Development Facilitation Team (DFT) – Review Comments

Project No: PR-2023-008842

Application For: SD-2024-00036-PRELIMINARY/FINAL PLAT (DHO)

Project Name: Tract P-1-A and Tract 1-A, Innovation Park

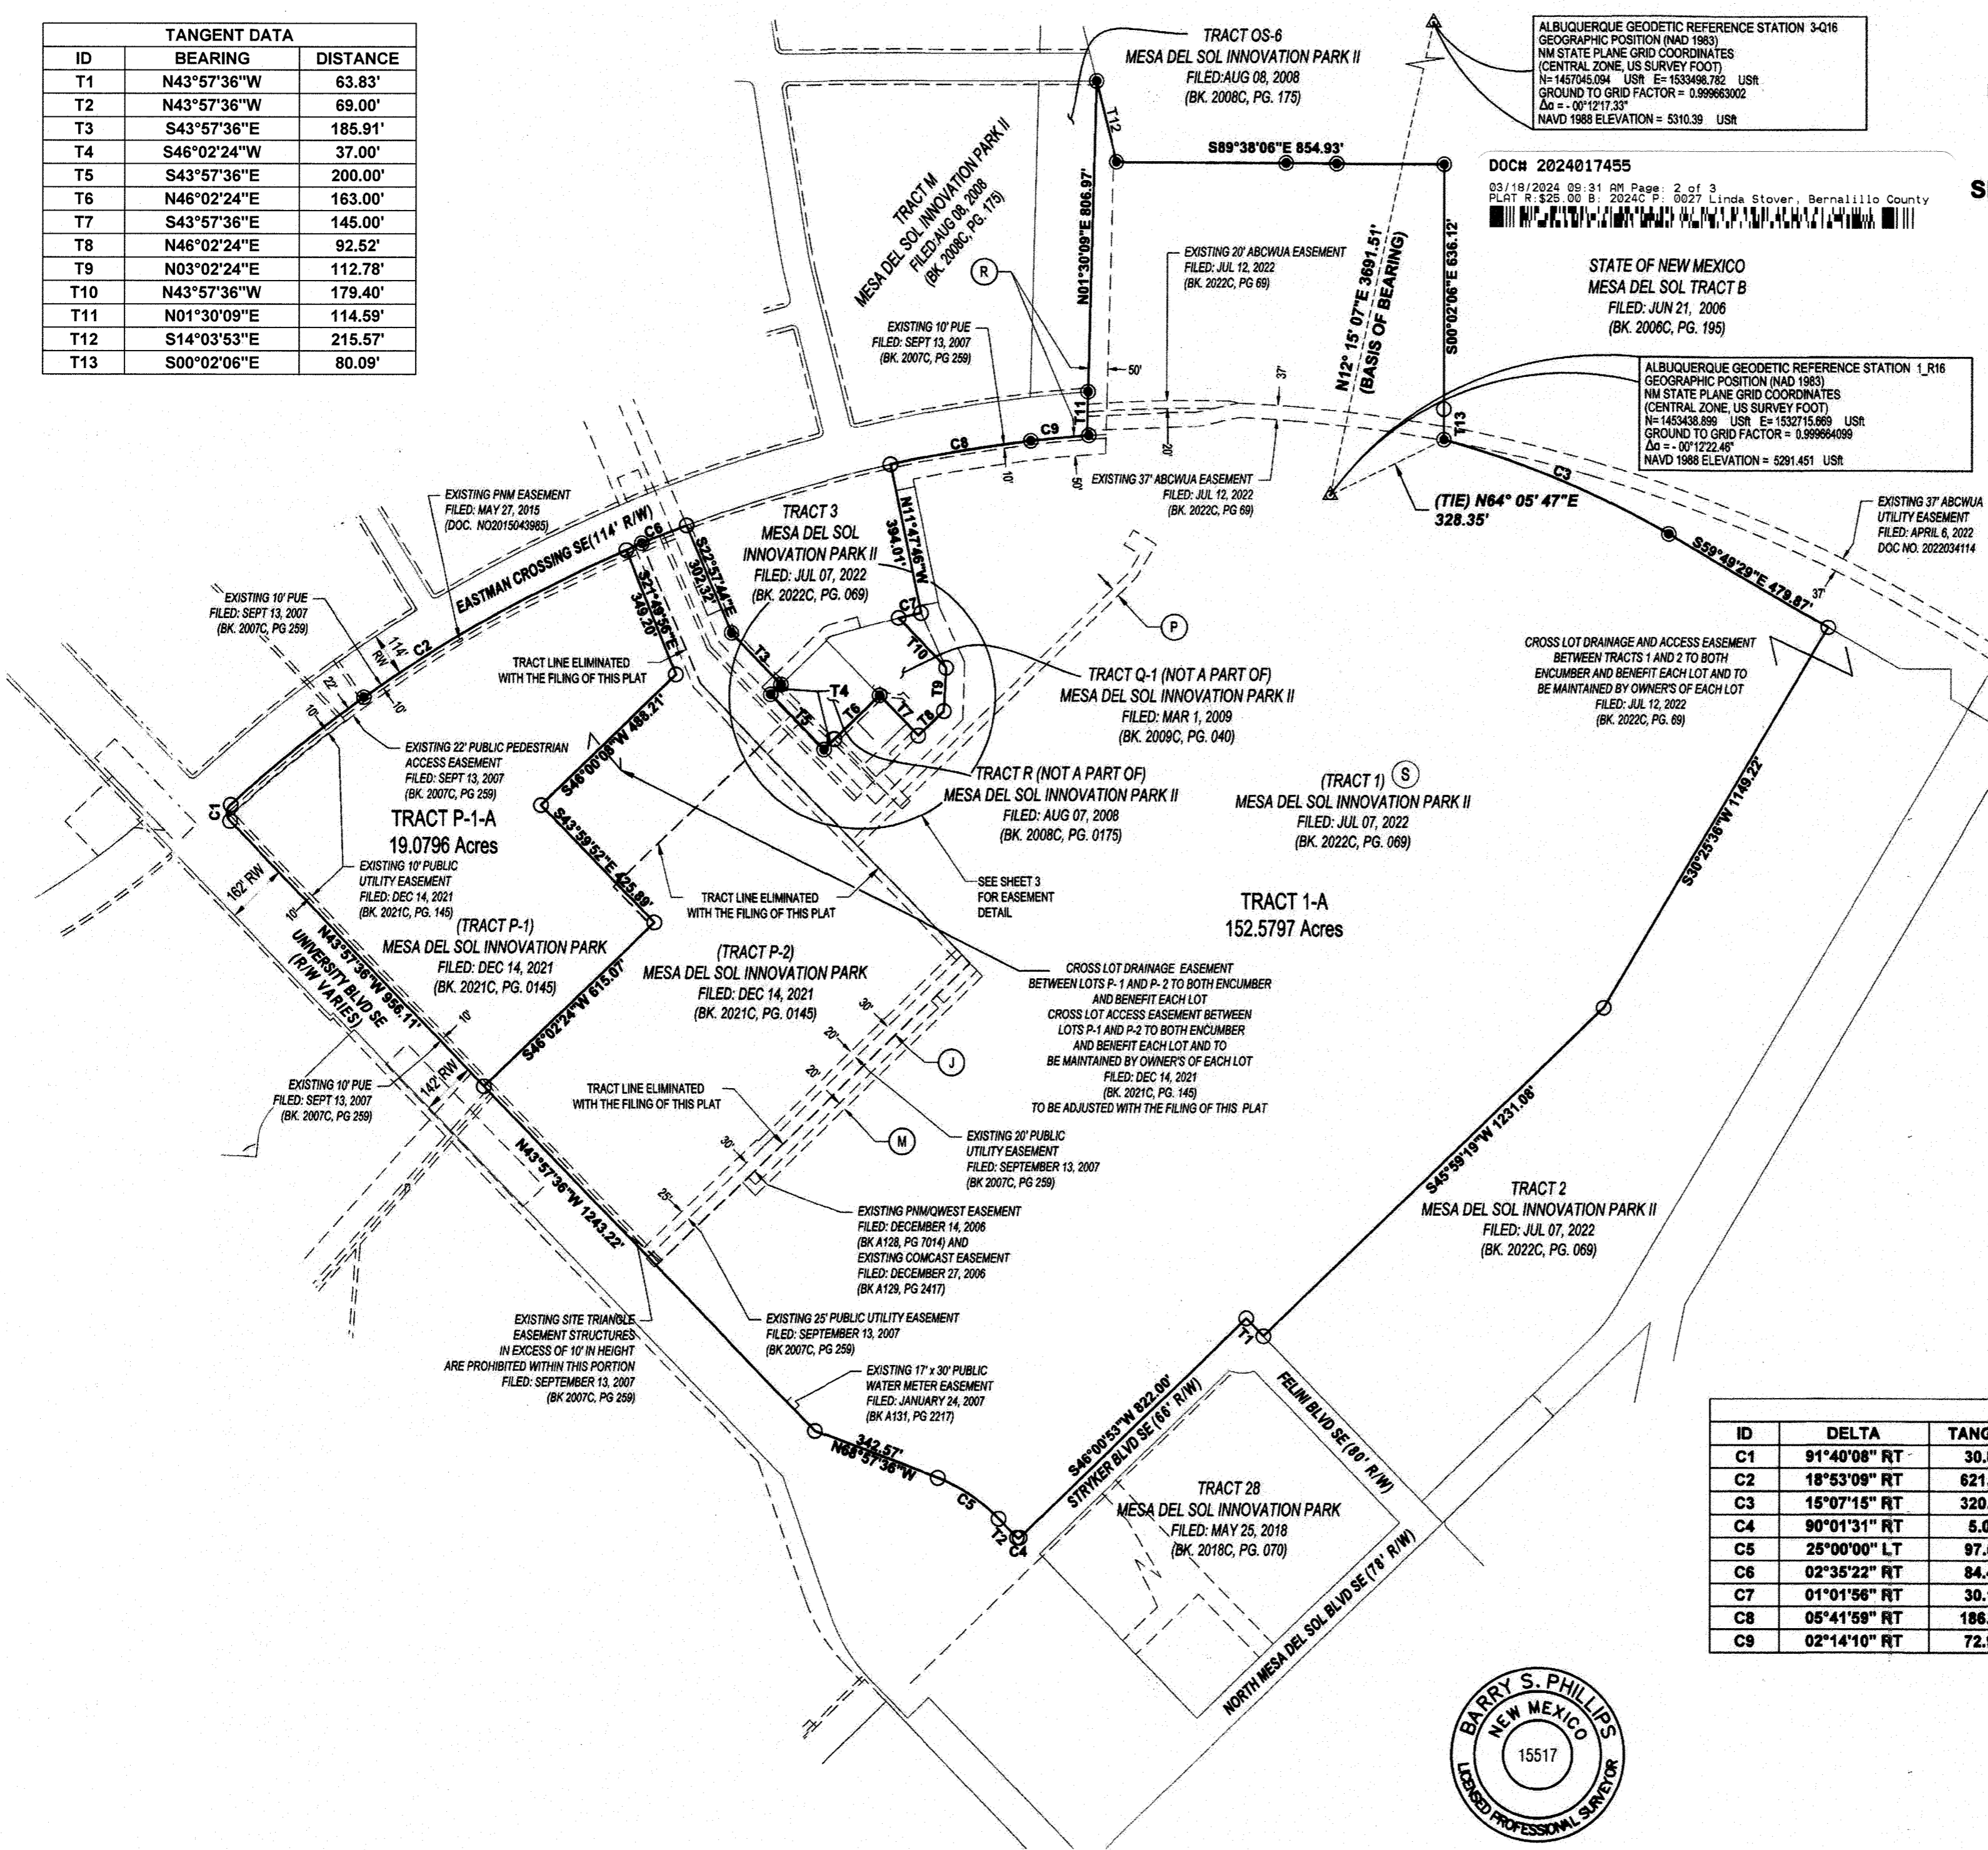
1. Please identify all existing easements adjacent to the Water Authority facility that include public waterlines.
 - a. Acquire line spots as necessary to ensure all lines are within the easements.
2. Otherwise, no objection to the proposed lot line adjustments.
